APPROVED
Limited building only review.
Permit holder responsible for full compliance with the code.

See notes on footing at garage door and upstairs bedroom windows

Project: Bauer Residence
Fayetteville NC

Elevations

SHEET
6

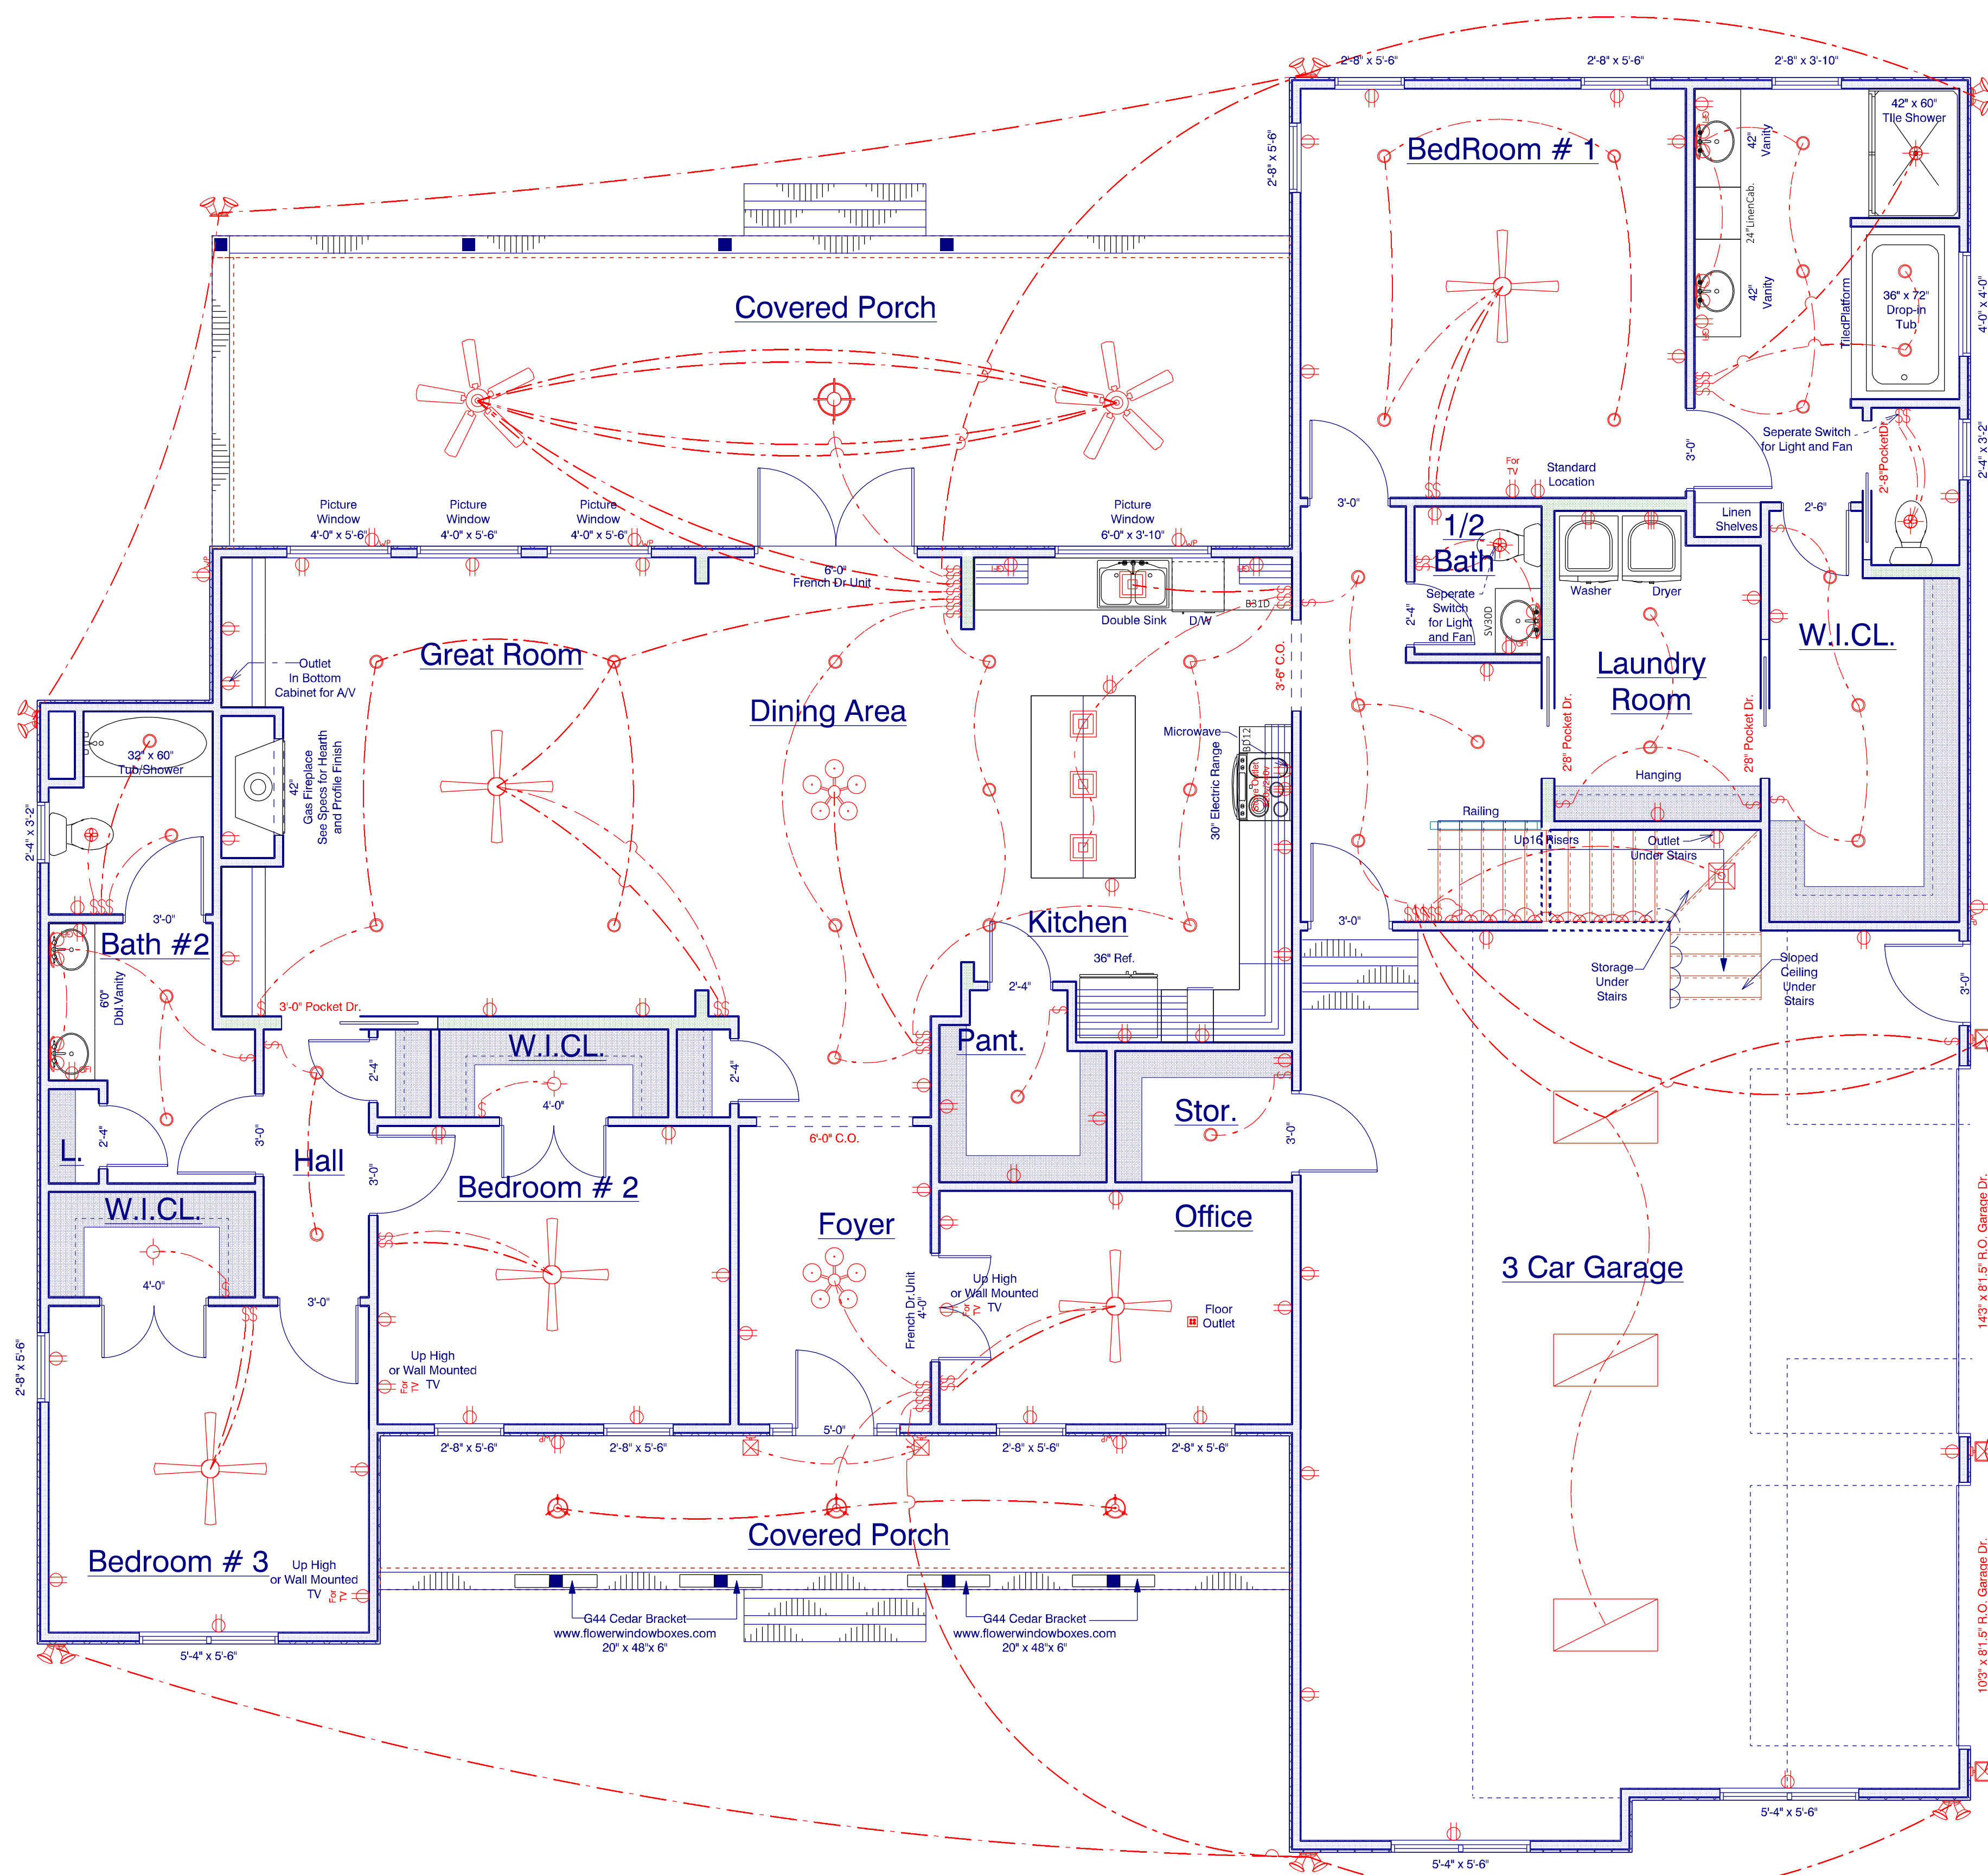
Windows must meet egress sizing
